Accessibility Review Report – DA Review

Project Title: Northside Private Hospital
Corner Racecourse Road & Faunce Street, Gosford

Date: 09 September 2019

Report Version: 9030_ADR_DA_v1.0

Figure 1 – Ground Floor Plan Mark-up

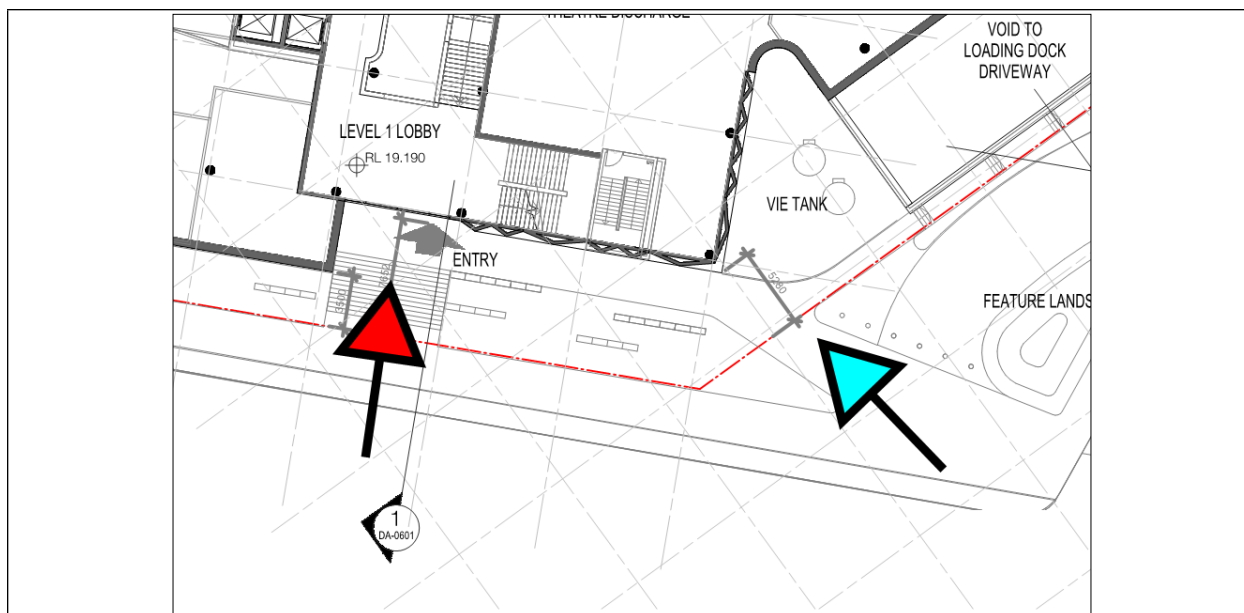
1. Height difference between Entry Plaza garden and internal floor level of 70mm is indicated. Step free-access is required to be provided at entrances. (RL14.12 – RL14.19)
2. Confirm a step-free entry is provided at entry from Private Road – as the RL indicated externally is 13.50.
